Planning Application No: 2026/62/91926/E

Address: 158 Hawthorne Way Shelley

Description: Change of use of garage to treatment room for hairdressing including installation of bi-fold doors to existing opening

The below plan indicates the clients' ownership boundary:

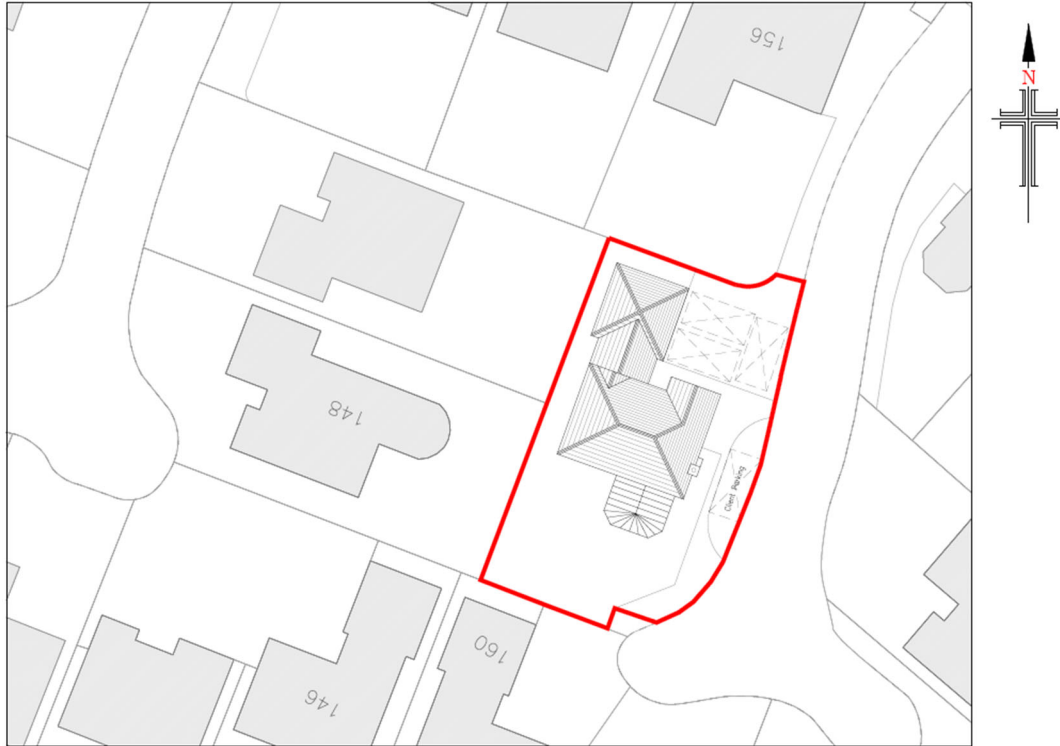
- Noting the comment in the Planning Statement regarding the area marked as ‘Client Parking’ I do not believe that this area is owned by the applicant and question the accuracy of the red line as it would appear to be from an indicative plan. The plan submitted with the application is not a Land Registry copy as it doesn’t show the WYK number. Can this be checked please?

- Even the plan shown in Appendix A of the Planning Statement (copied below) looks to be an alteration. Usually, a property boundary is indicated by a thick red line. The image below shows a thick boundary around the North, West and South of the property which is also highlighted by the red line. When it comes to the East of the property the thick line continues alongside the property as highlighted by the yellow line. This would indicate that the boundary follows the current line of the fence. It appears though that the red line has been re-drawn outside of the original boundary as there is no thick line underneath it.

The area currently shown in Green in Appendix A of the Planning Statement indicates the service strip for the cul-de-sac and I understand that ownership for this resides with Kirklees Highways so it would appear unusual that the service strip should fall under the ownership of the applicant. It should also be noted that the service strip is no longer visible on the applicants drive as the previous owner and current owner have resurfaced the drive and removed the line which indicated the service strip. The service strip can clearly be seen on the other 5 properties in the cul-de-sac and in historical google images of the property.

Proposed Site Layout
Scale 1:250

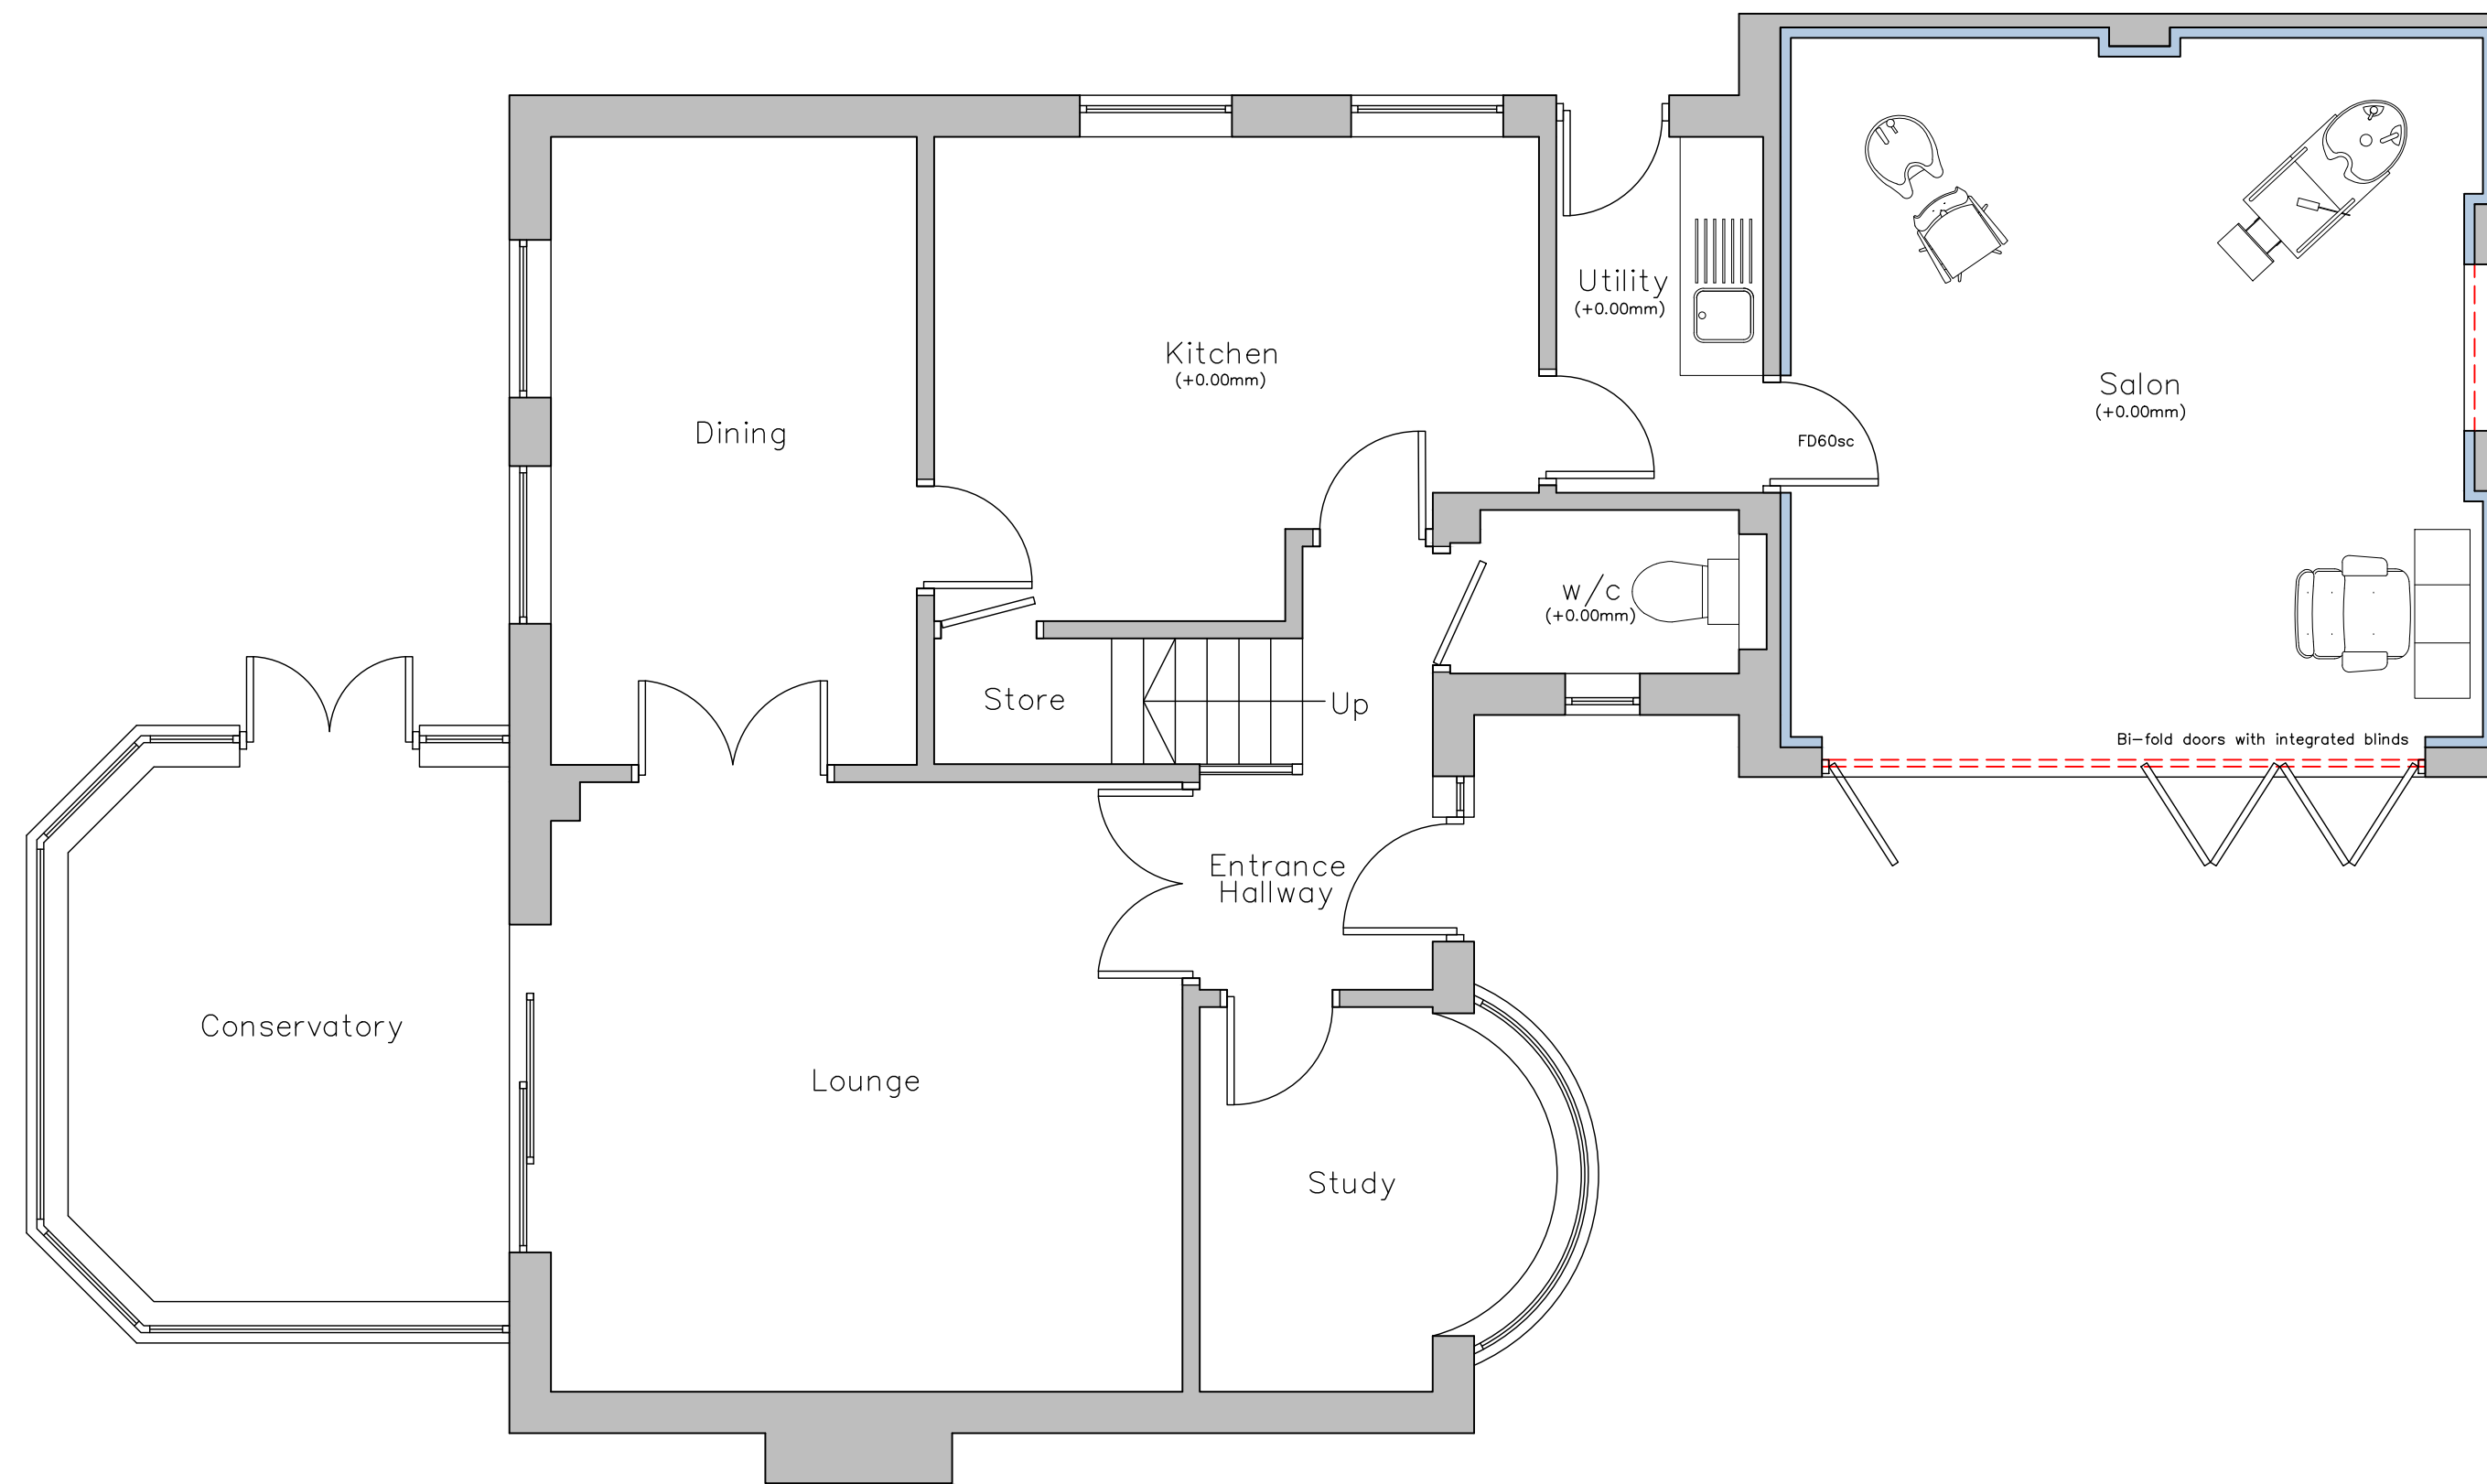
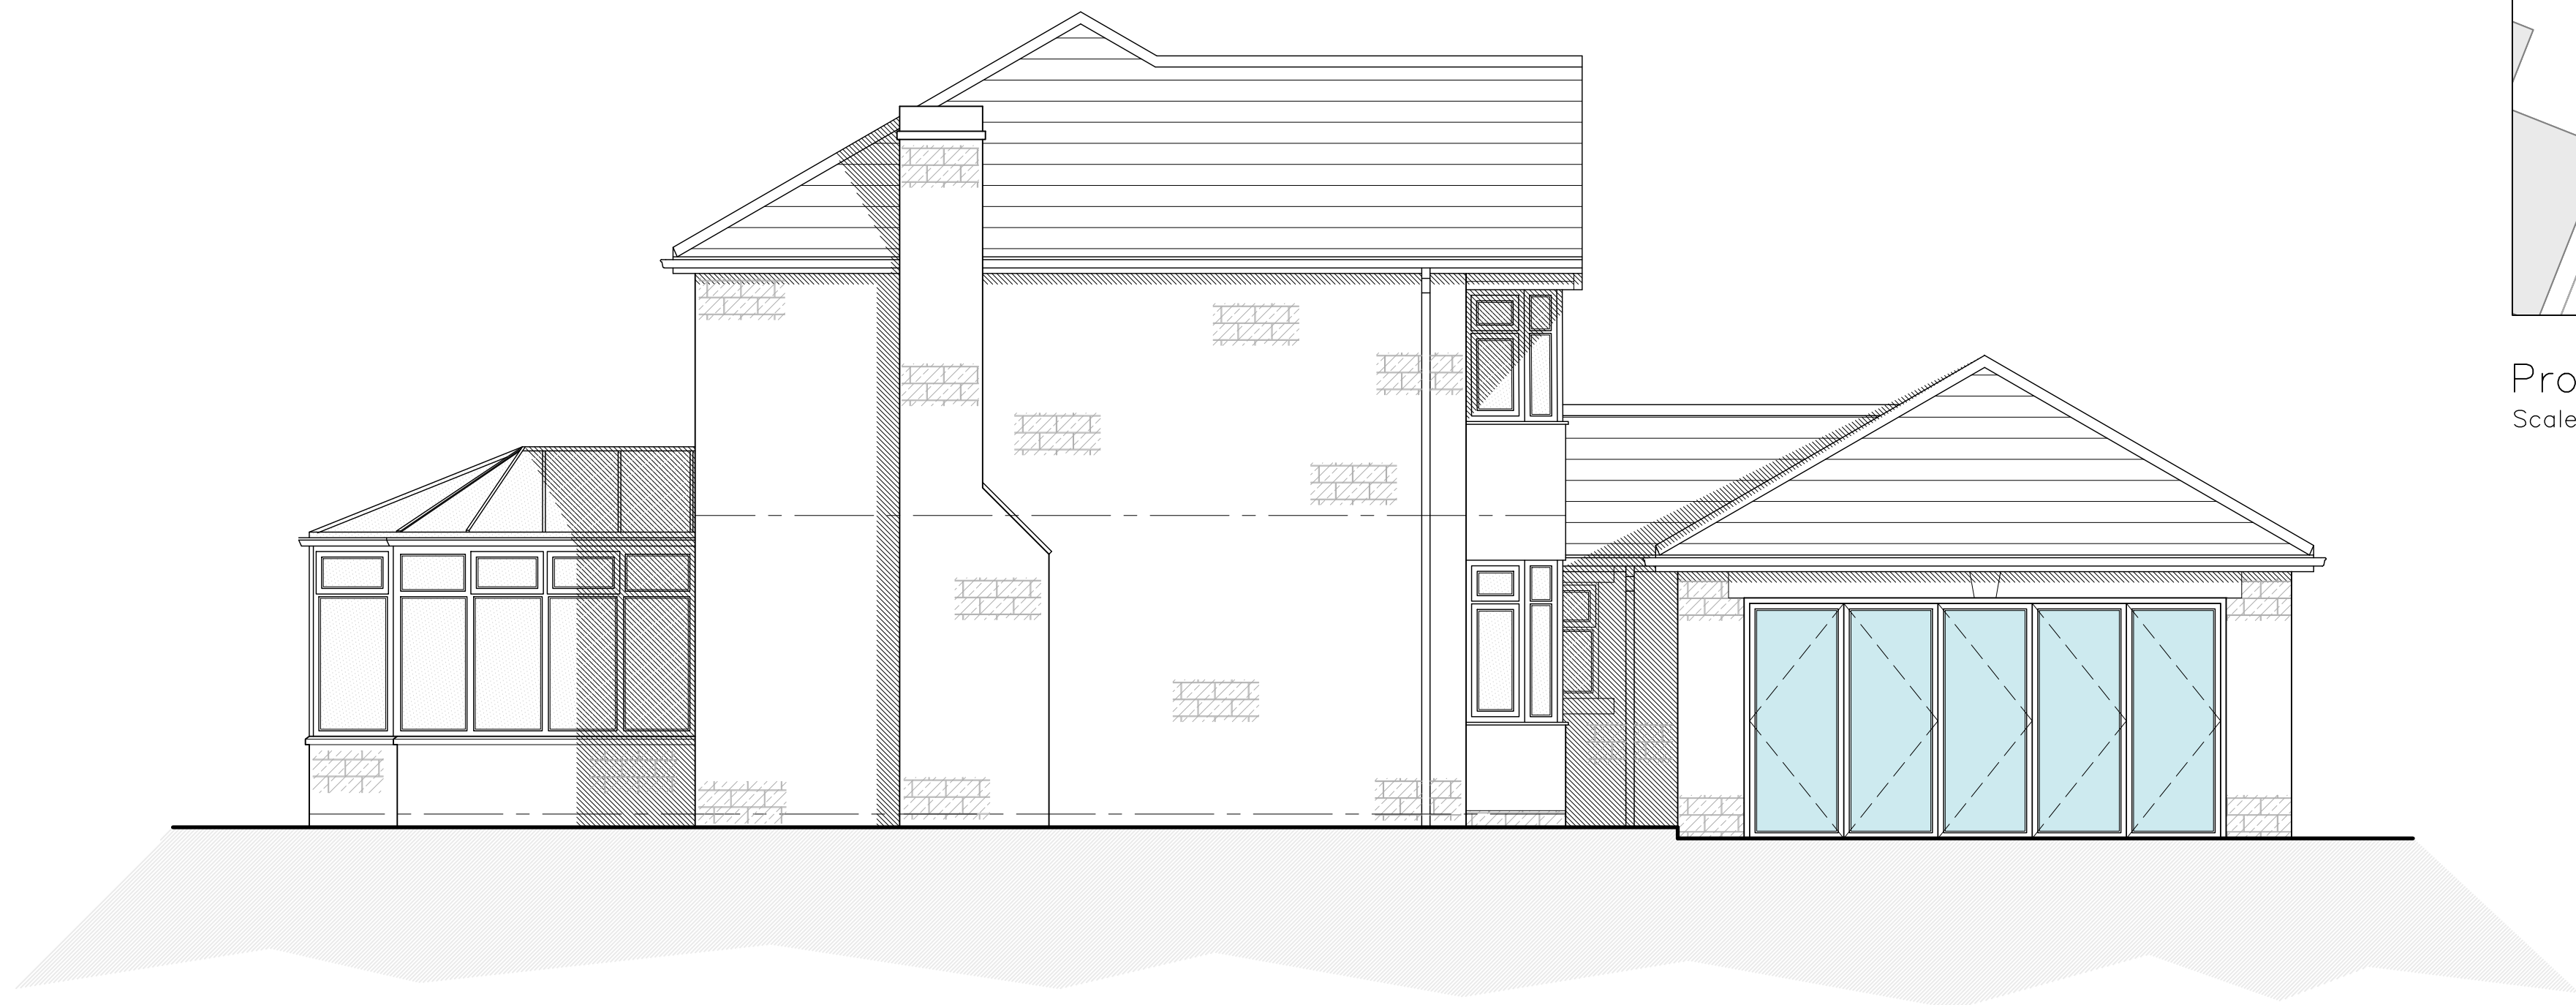
- The Planning Statement shows 3 parking spaces on the drive with two up to the property boundary. This doesn’t appear to take into account the ability to open the proposed bi-fold doors which are likely to require one metre of space to open. I’d question if there is space for 3 cars to be parked on the drive (excluding the service strip). Even though the width of the drive has recently been extended I don’t believe that the third car would be able to park across the bottom of the drive and would have to be across the service strip or protruding into the road. This makes it difficult for the neighbour opposite to reverse out of, or into their drive.

- As the drive has recently been extended (presumably without planning permission) does the applicant plan to make any changes to the area that has been marked as 'Client Parking' if it is deemed to be within their property boundary?
- Access to the business isn't clear but I presume it would be through the bi-fold doors; therefore, a clear gap would be required at all times between the bi-folds and the cars on the drive.

- b. The proposed space of 5.2m x 5.2 appears to be a particularly generous/spacious for one customer and the hairdresser at any one time. This would be double the space that was used at 46 Westerly Lane, and the size of the space lends itself to be used for multiple staff and customers.

- b. Some customers were observed to be at the property for up to 2.5 – 3 hours. With a single seat shown in the plans it's not clear where these clients will be whilst the applicant cuts the hair of the other clients seen to arrive at the property during the same time period. This suggests that there is a 'treatment room' separate from the hairdressing.
